Submission from:
Zora and Frank Coric
61-63 Greenway Place,
Horsley Park NSW 2175

June 9, 2016

**Re: Oakdale South Industrial Estate (SSD 6917)
Erskine Park, Penrith LGA
Applicant's Response to Submissions**

# Landscape Concept Master Plan

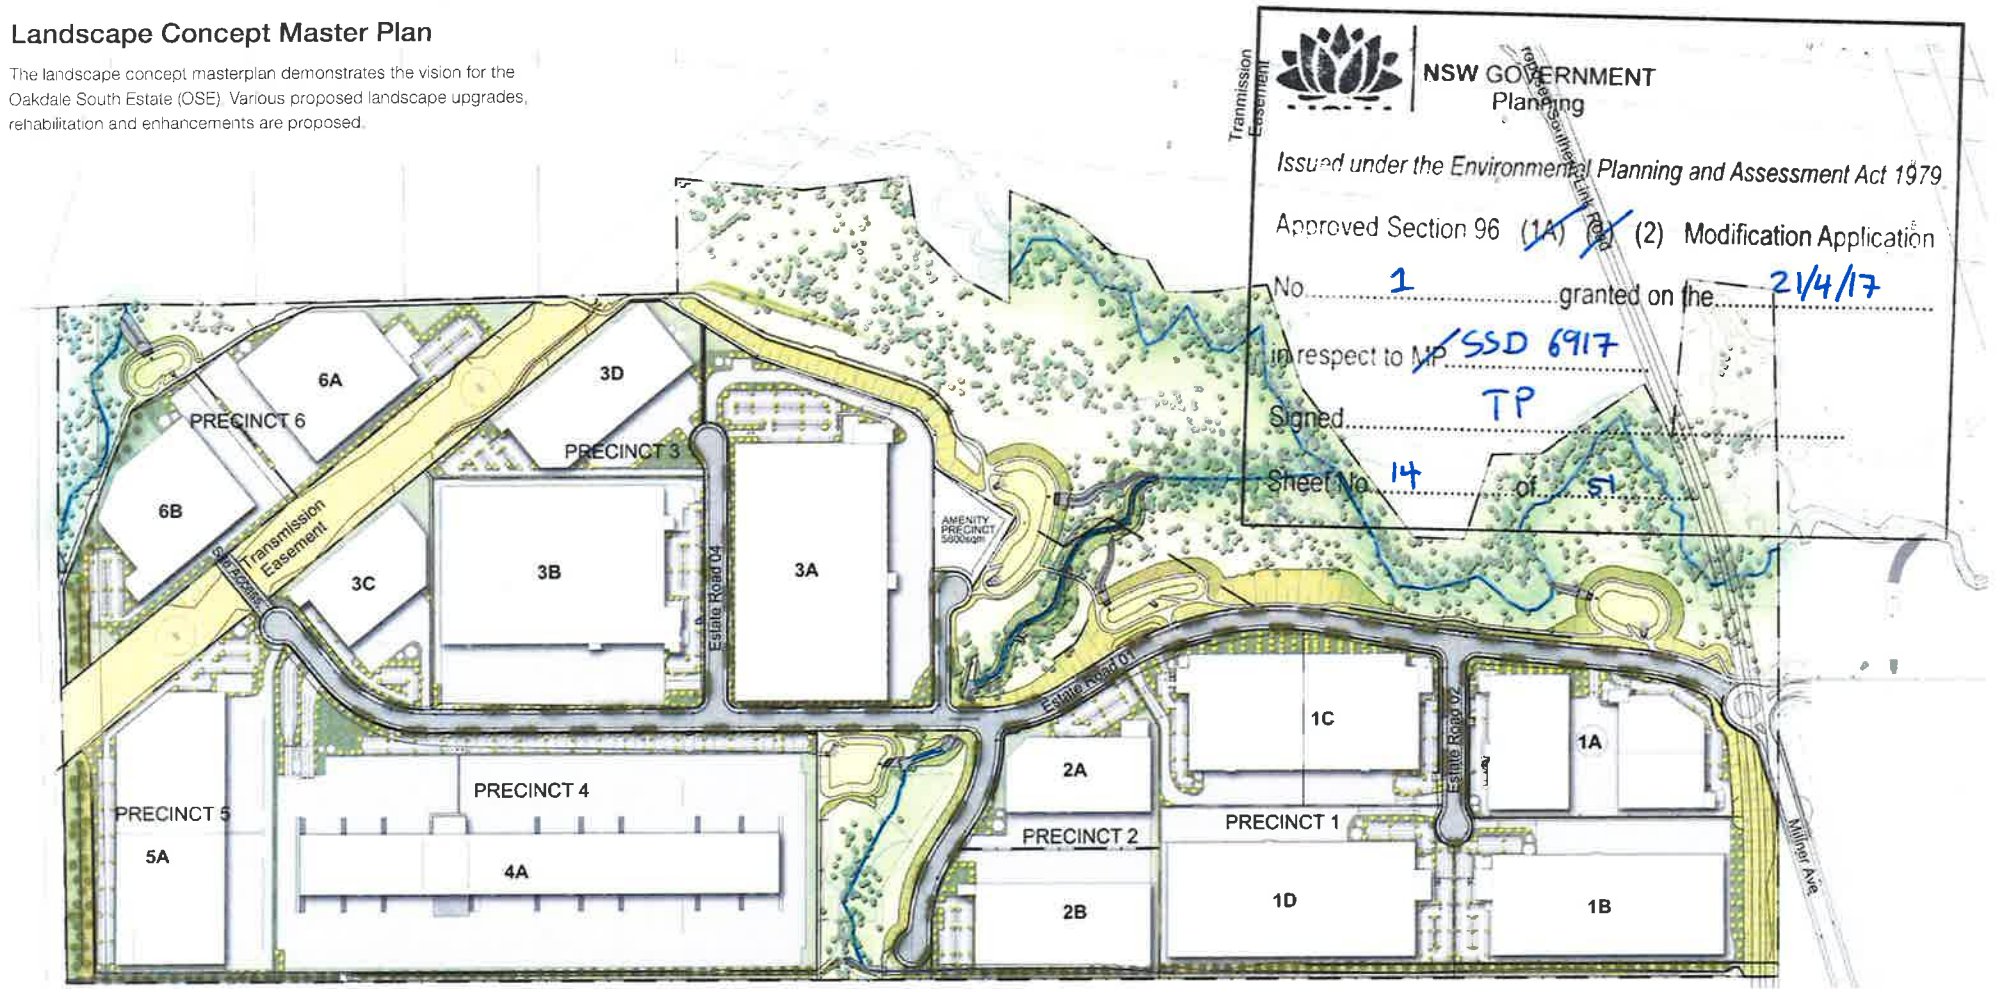
The landscaping drawings and VIA are unclear as to the extent of landscaping treatment to be applied to the Eastern boundary. Will it extend along the entire Eastern boundary, or be limited only to the area directly around the noise wall. We believe that the landscaping treatment of 10m in width, as illustrated in Section C-C of Appendix D to the RTS, should be extended along the entire length of the Eastern boundary. This would help to minimise our views of the unsightly buildings and rooftops of the OSE, as well as helping the proposed rezoned RU4 land on the Jacfin site.

Eastern Boundary Landscape Section

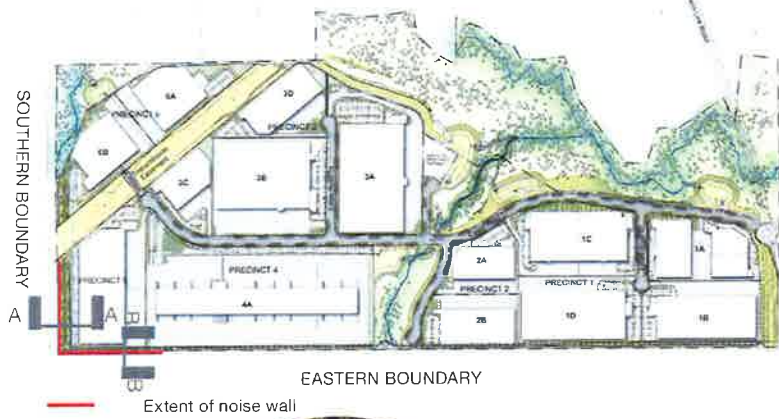
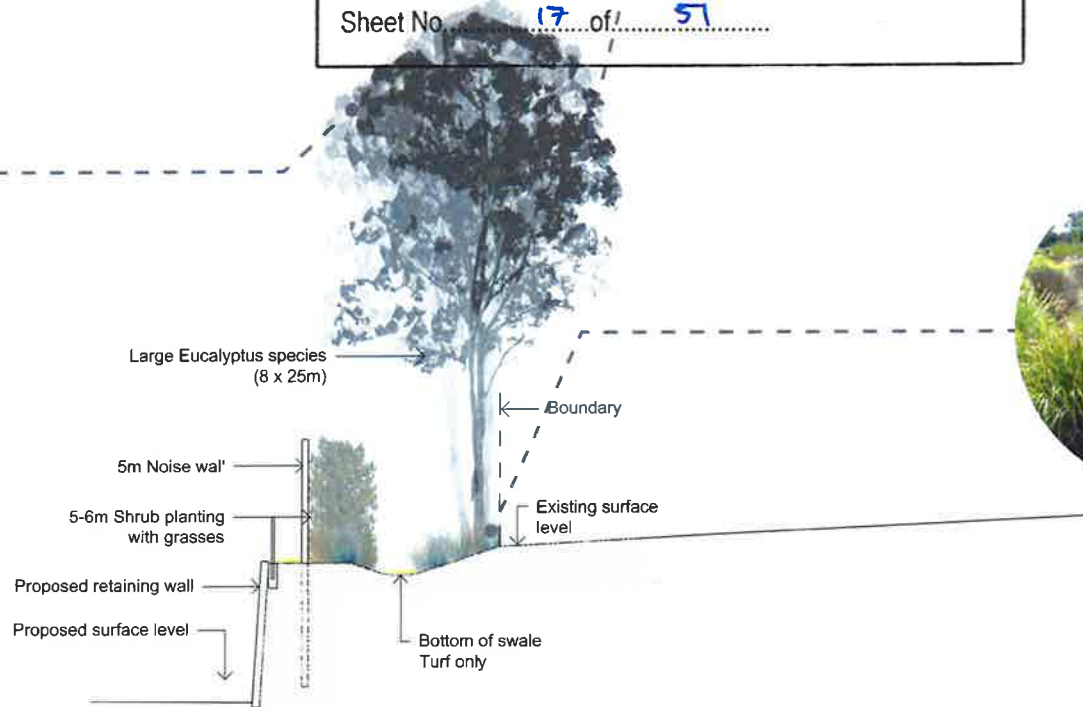
The Applicant's RTS does not provide any response to the issues of glare and lighting. Landscaping would also help to mitigate these impacts. The Department should not approve this application without the 10m wide landscaping treatment along the whole length of the boundary.
